Your Ref: 2024/91591

22nd April 2025

Land off Bankwood Way, Birstall Retail Park, Birstall, Batley - Variation conditions 2-6, 15, 29 on previous permission 2021/92528 for erection of retail development, associated parking, servicing areas and landscaping

Thank you for consulting Yorkshire Water regarding the above proposed development. We have the following comments:

APPROXIMATE LOCATION OF WATER MAIN TO BE REMOVED.

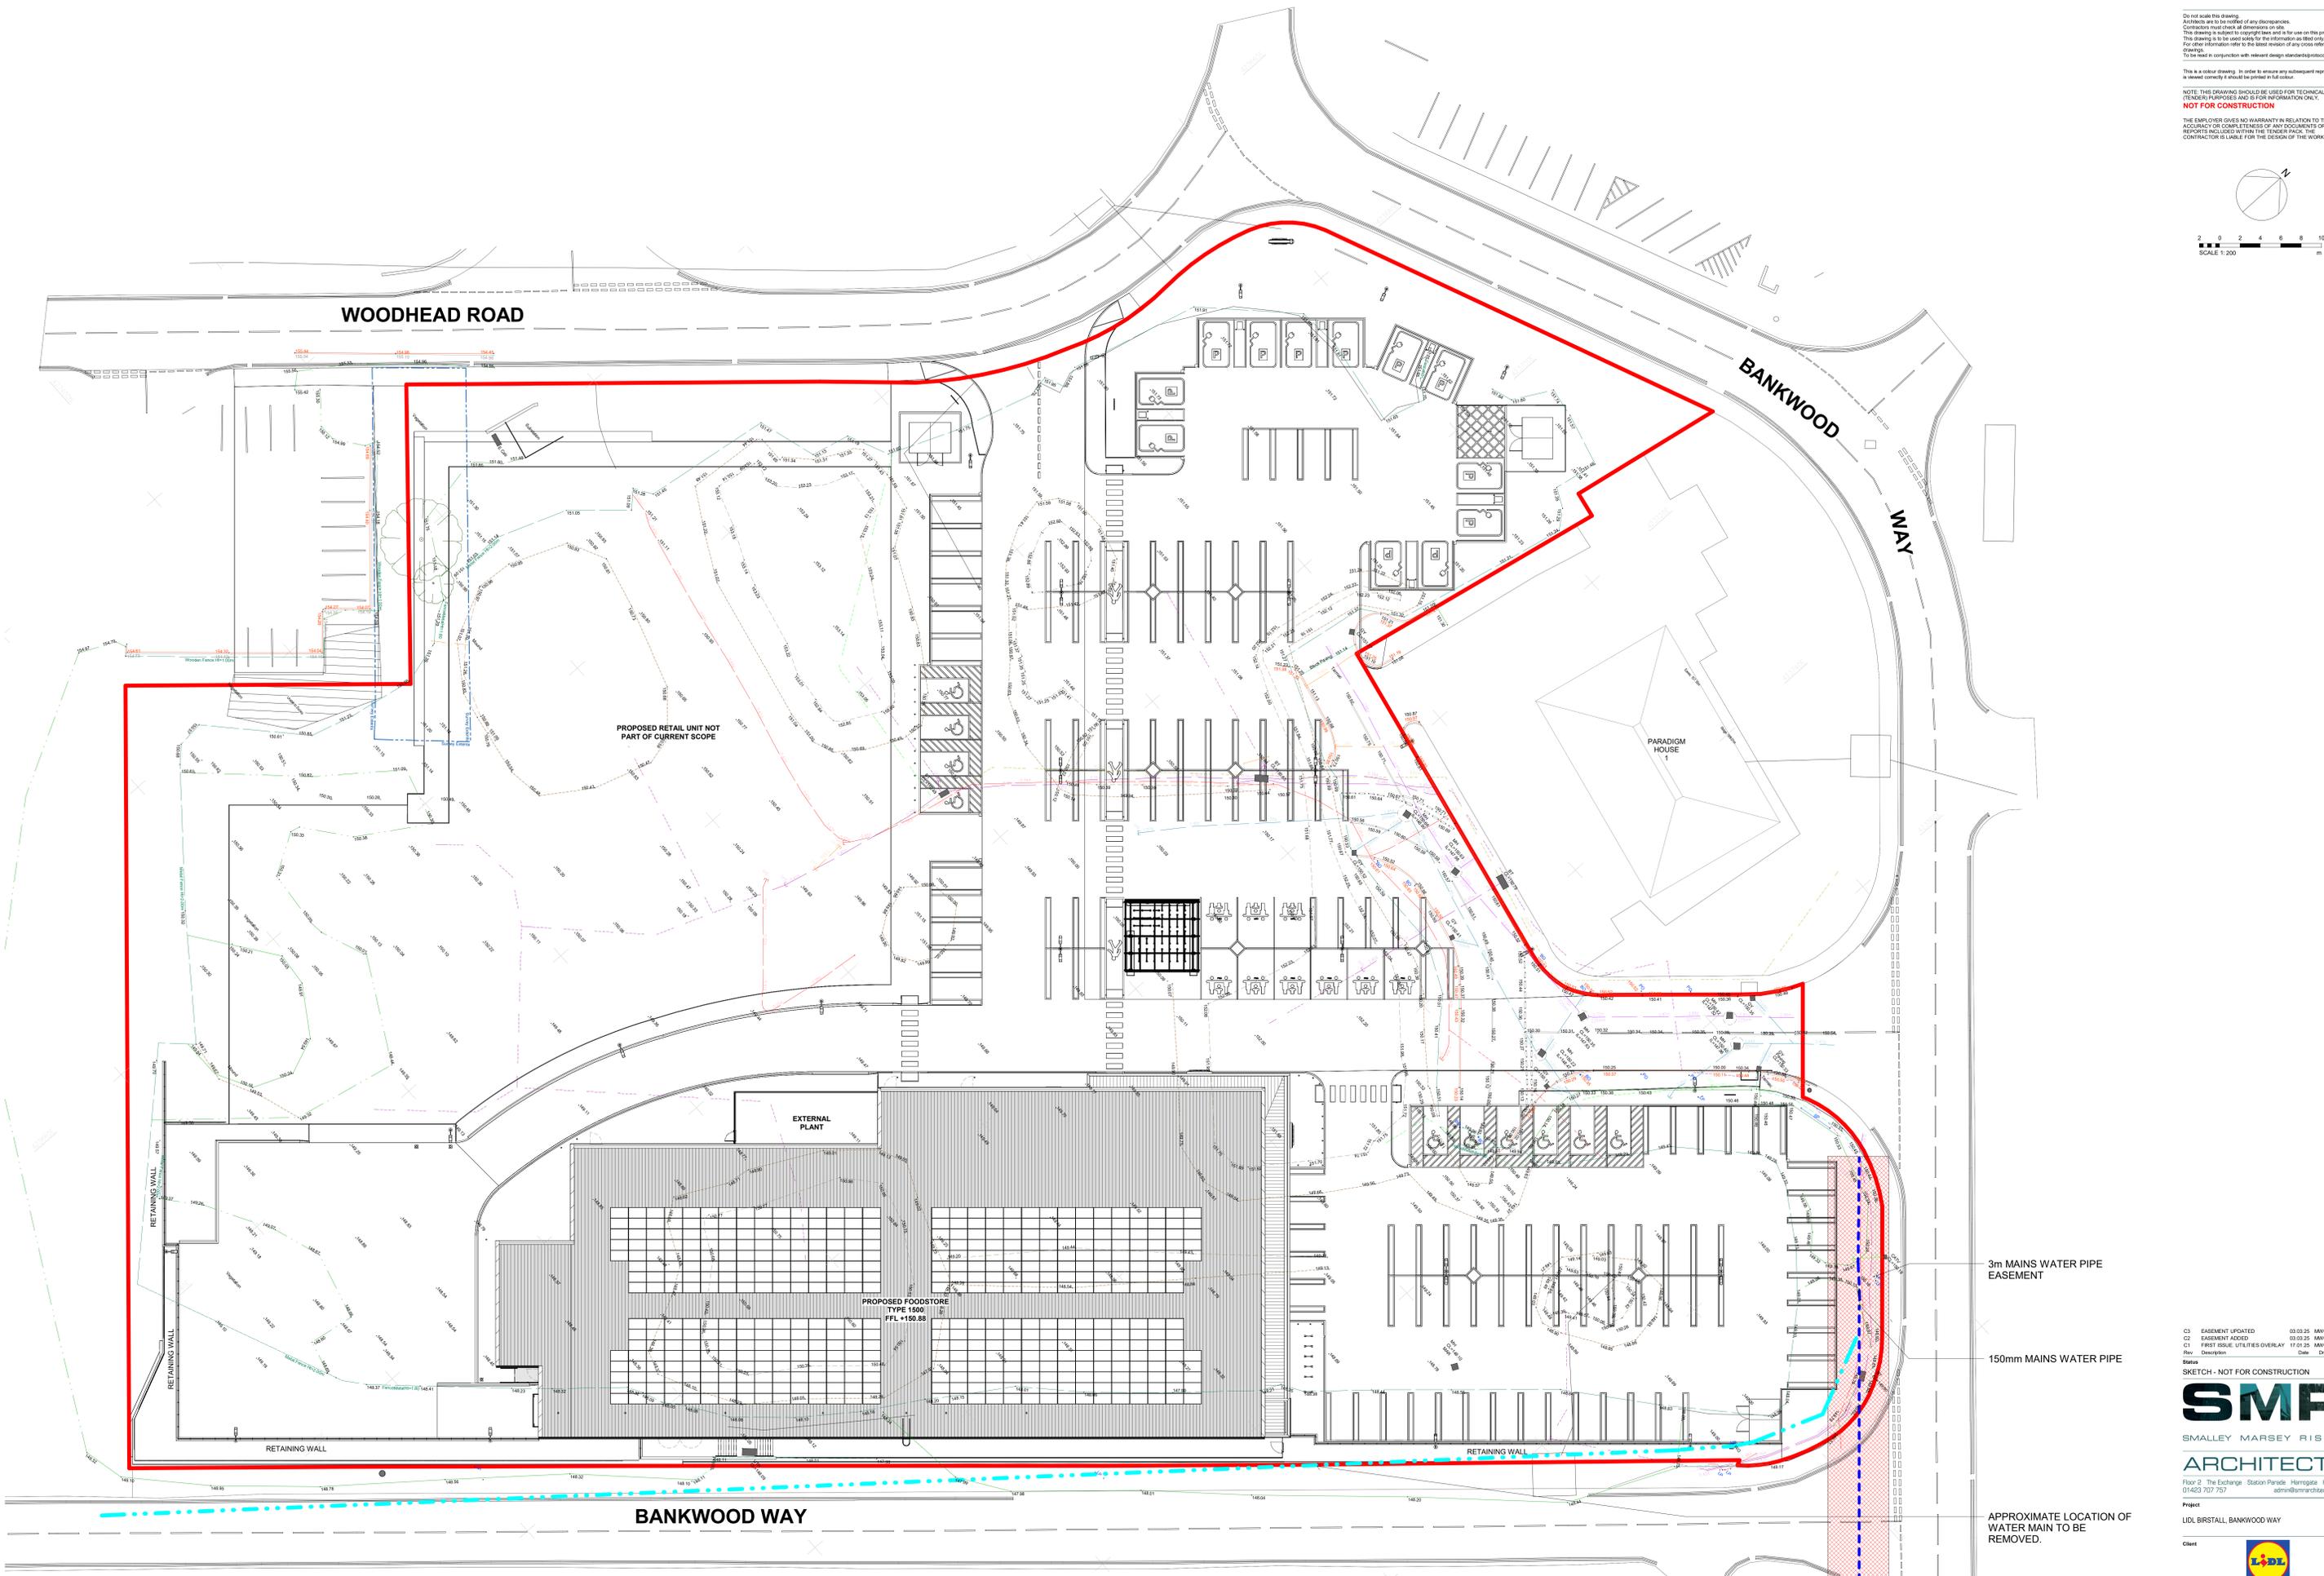
It should be noted the 150mm diameter ductile iron water main recorded crossing the site is currently isolated and must be formally abandoned before any construction works start. For further information, please call 0345 120 8482 (option 2) to discuss the abandonment works with our clean water team.
